Engineers Comments Regarding Surface Water Drainage

Application Reference:	BN/76/26/DOC	Reviewer Reference:	ADC/EXT2/113
Planning Officer:	Amber Willard	Date of Review:	30/07/2026
Site Name:	Land South Of Wandleys Lane Eastergate PO20 3SE		
Application Description:	Approval of details reserved by condition under BN/46/25/PL relating to conditions 4- Surface Water Drainage and 9- Maintenance & Management of Sustainable Drainage Scheme.		
Assessment Number:	1

Response	Condition 4: Further information required Condition 9: Further information required
-----------------	---

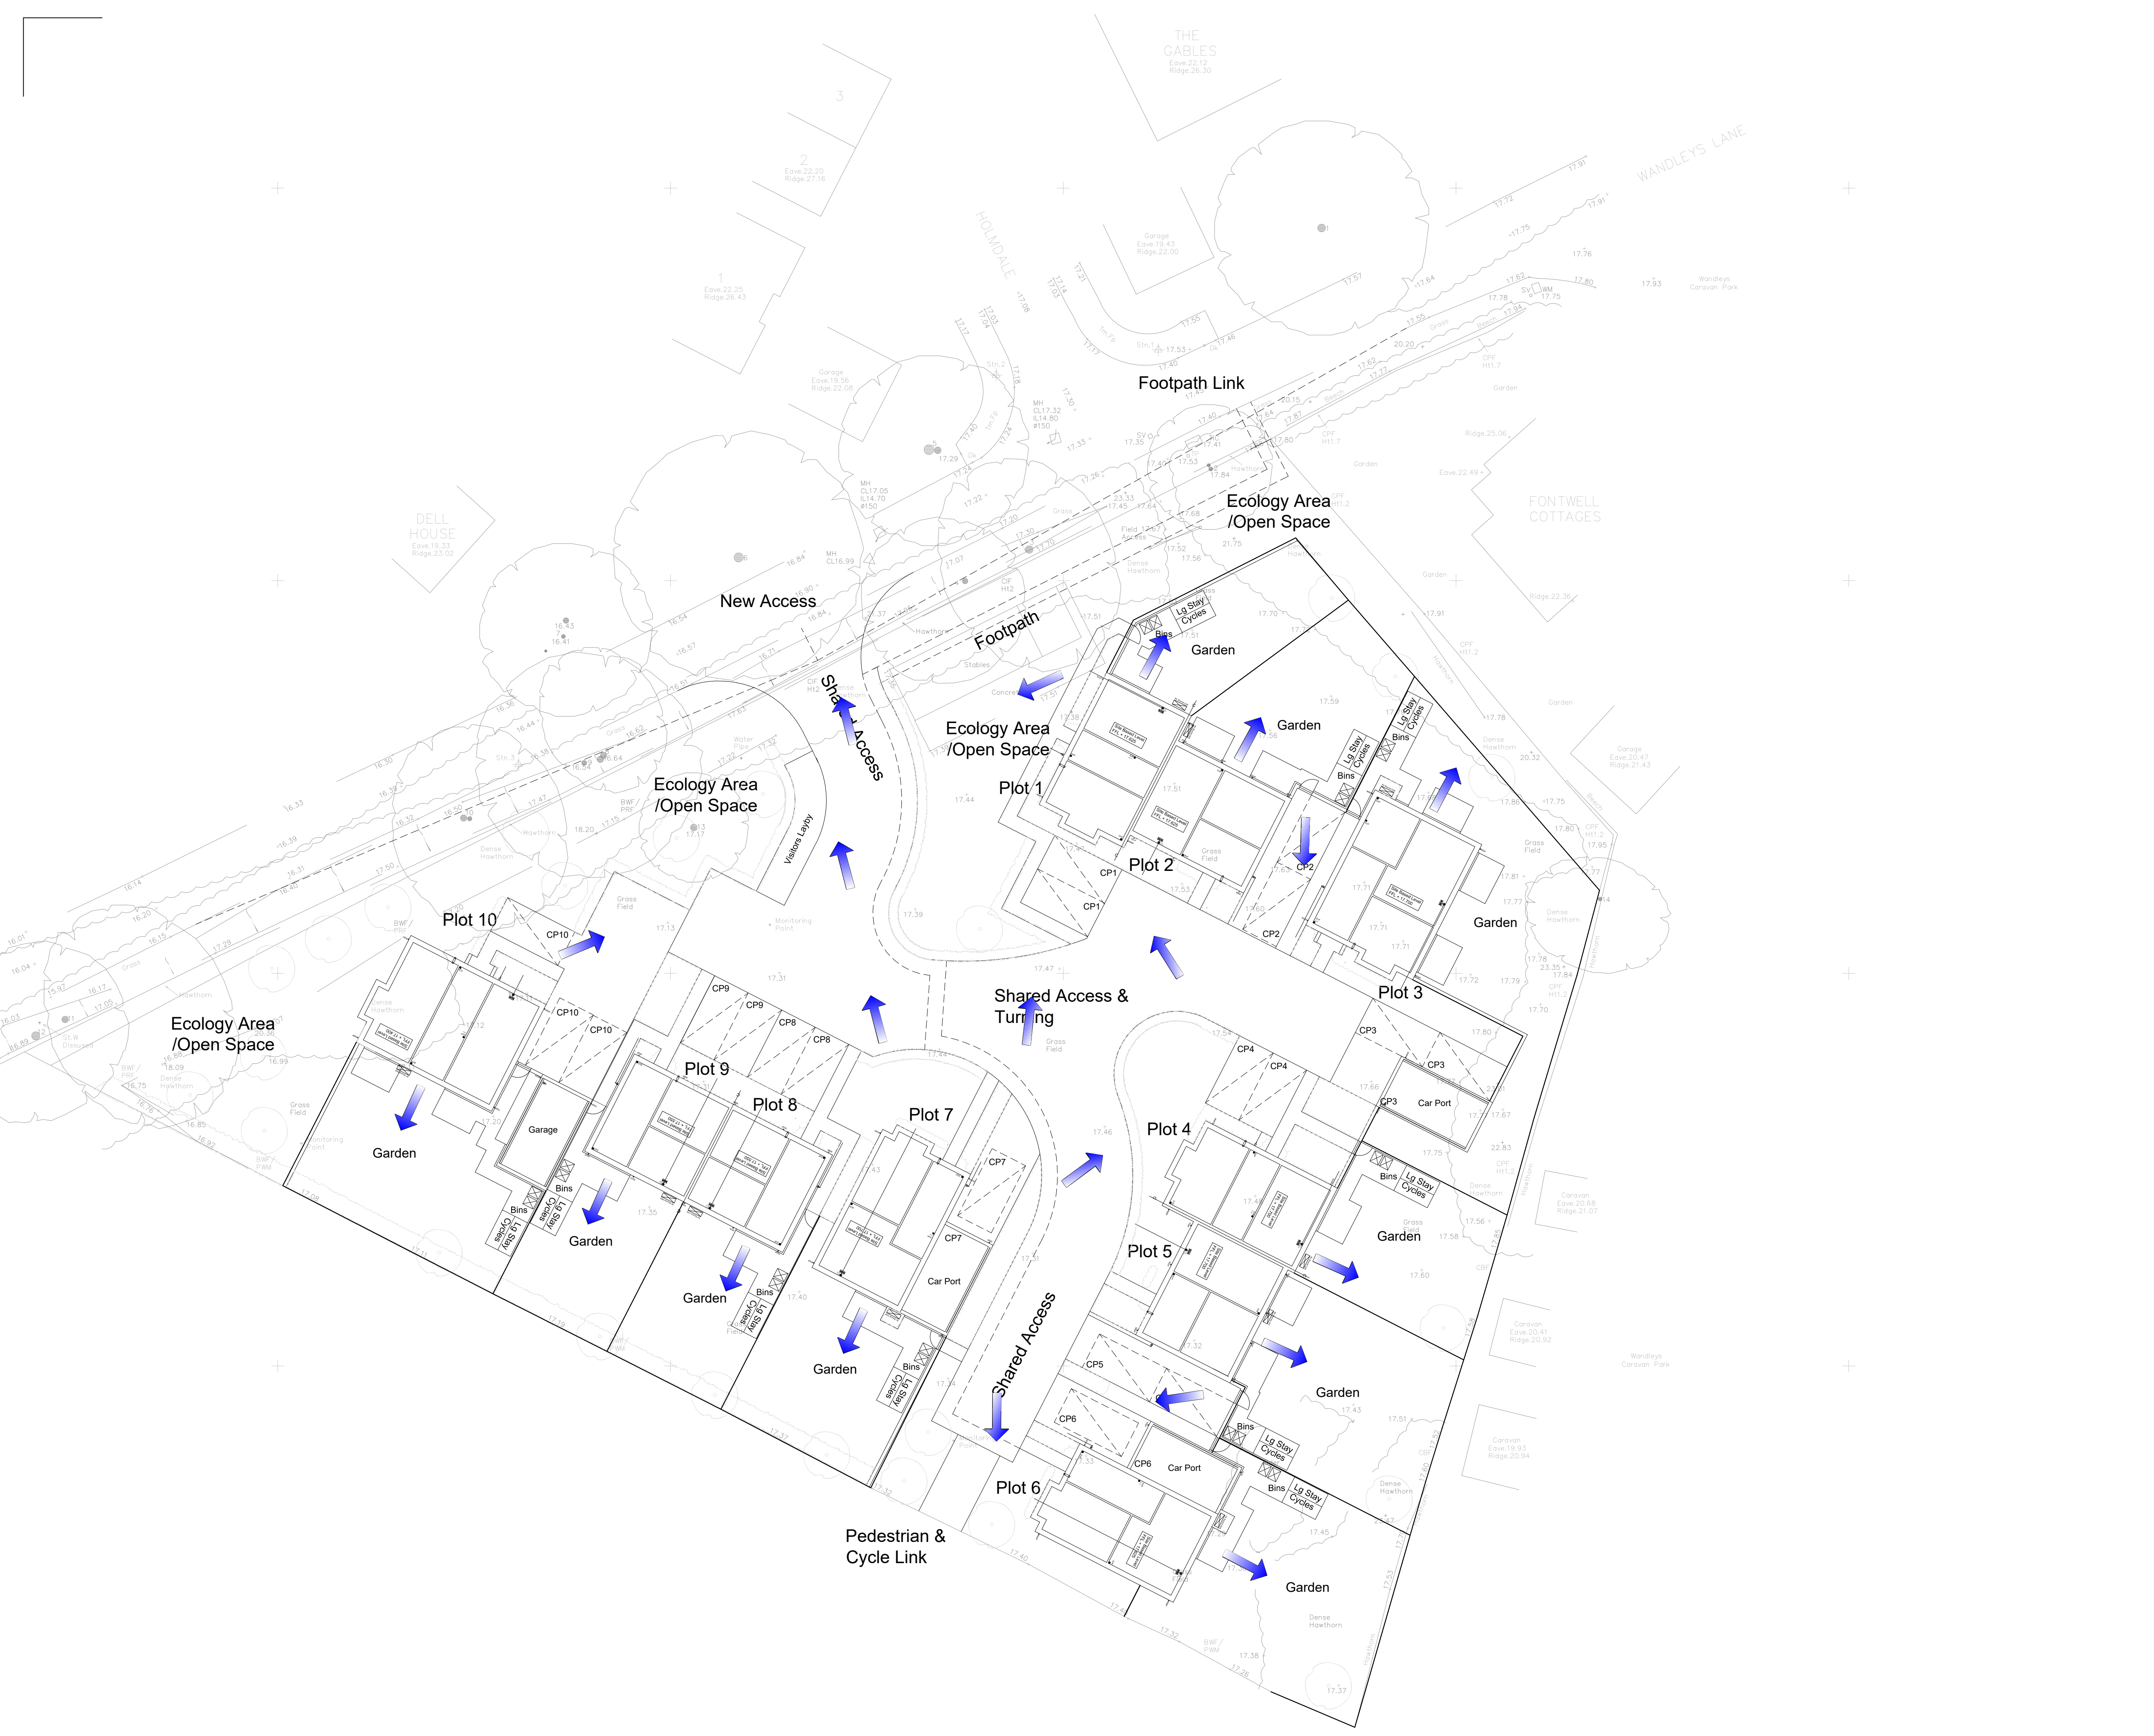
Designer Response	ADC Drainage Comments			
Date:	02/06/2026				
Condition Number: 4 Look at "Response to engineers comments regarding surface water drainage (Word version)" for prior comments					
Comment Number					
1.	OK				
2.	OK				
3.	Please refer To Exceedance Plan drg. No. 476988-503_P01- Exceedance Flood Routes. Please refer to descriptor file: FEH_Point_Descriptors_494812_ 106233_v5_1_0FEH File sent via email on 10.06.26	Noted. Comment closed.			
4.	OK				
5.	The provision of water butts to each plot and utilising permeable paving within the development provides amenity benefits. Rain gardens have also been added, collecting rainwater from some RWP's, which provides attenuation. The planting	Noted. Comment closed.

8.	Please refer To Exeedance Plan drg. No. 476988-503_P01- Exceedance Flood Routes.	Noted. Comment closed.			
9.	OK				
10.	Please refer to updated calculations which now show the permeable paving summary tables along with the flow/time graphs, which include the half drain down times for each storage feature.	Noted. Comment closed.			
11.	Please refer to drg. No. 476988-201_P02- Levels Layout	Noted. Comment closed.			
12.	The road long section does not show any type of construction but only the vertical	Noted.
